Town & Country Planning Act 1990 (as amended)
Town and Country Planning (Development Management Procedure) (England) Order 2015

Application No: LU/218/20/PL
Site Address: Flintstone Centre East Street Littlehampton BN17 6AW
Description of works: Erection of new fencing & gates to the rear & sides of building & removal of wire mesh fencing & gate between the playground & building. This application affects the character & appearance of the East Street Conservation. This application is in CIL Zone 4 (Zero Rated) as 'other development'.

Thank you for your internet representation made on 20th September 2020 which has been recorded as an objection with the comments as follows:

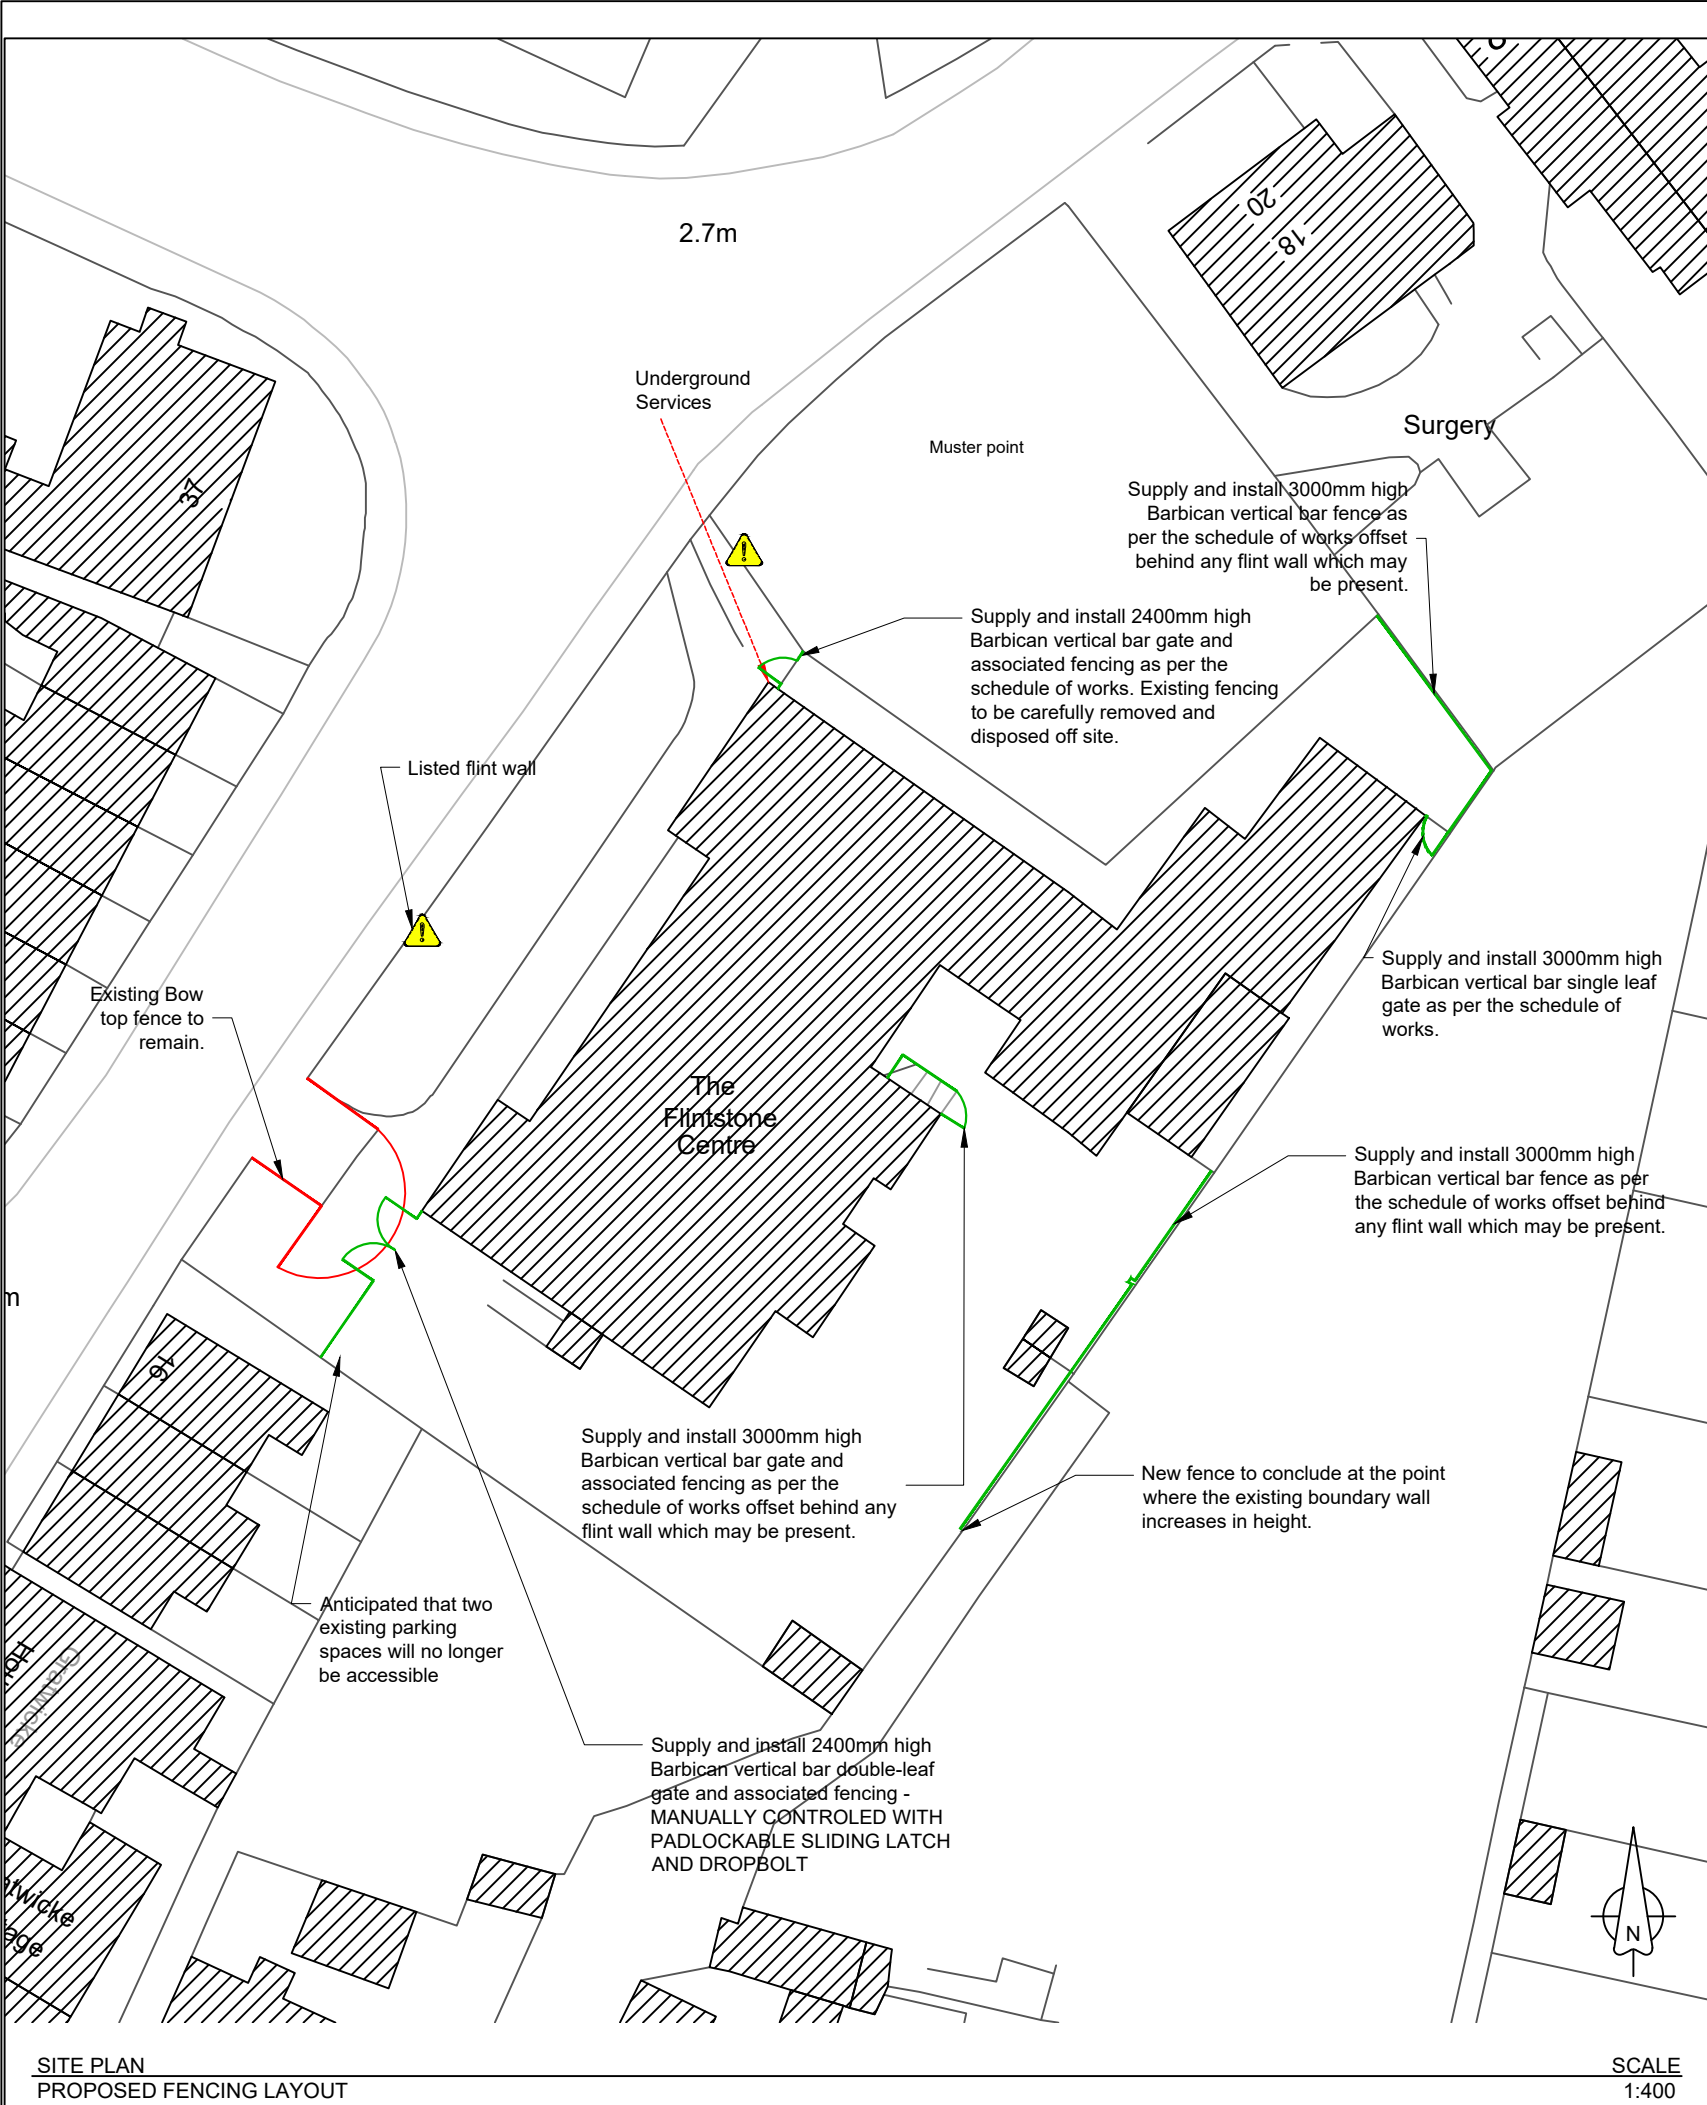
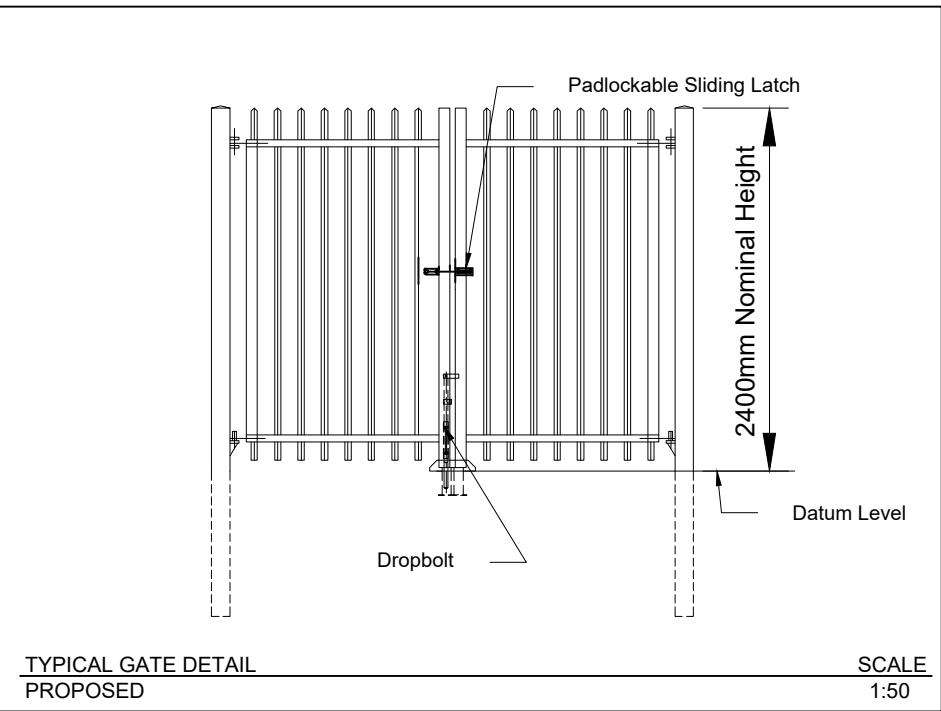
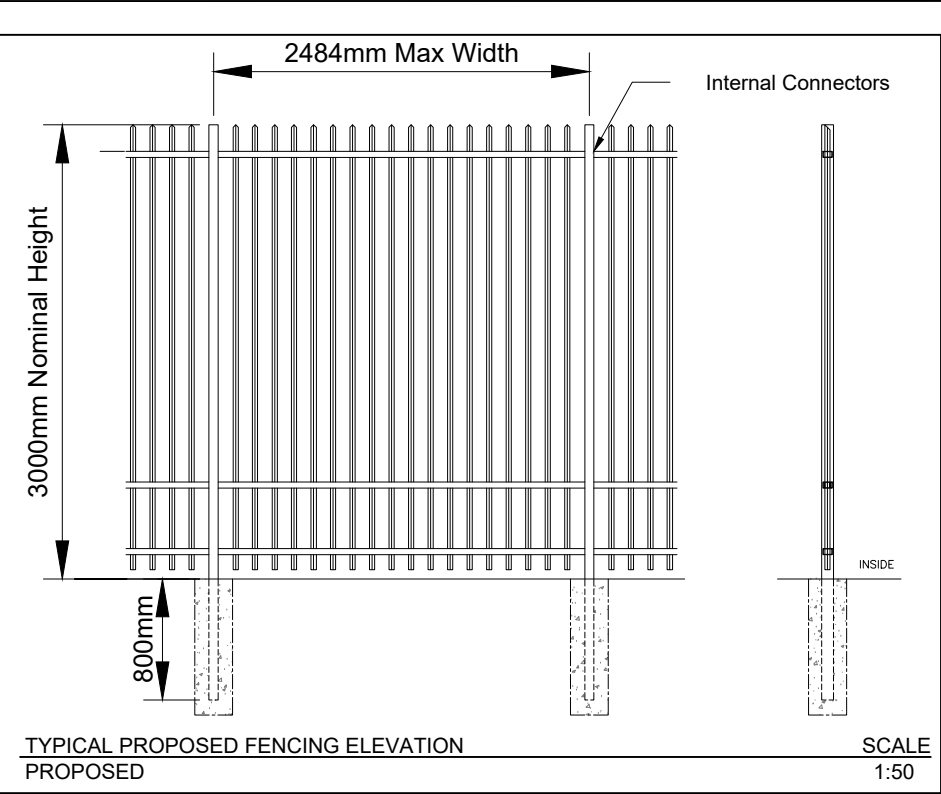
The need for security of the site is fully appreciated. However, the fencing proposed at the front of the site is considered too bland and industrial in appearance. This will detract from the main elevation of the building which has ornate detailing yet is of a modest and almost domestic scale. It will, therefore, also detract from the character and appearance of the conservation area, together with the settings of the listed buildings mentioned.

Any fencing at the southern part of the site needs to be set back from the front elevation of the building, similar to the setback proposed for the new fencing at the northern end, otherwise it will crowd and detract from the important main facade, particularly since the new fencing will be 3 metres in height.

Given the importance of the building to the history and development of Littlehampton, its high heritage significance and contribution to the quality of the conservation area, the Panel suggest that purpose made fencing of a more suitable appearance should be provided. A Victorian pastiche may not be appropriate or desirable but fencing which, for instance, interprets some of the qualities of the building in a modern and innovative way would be.
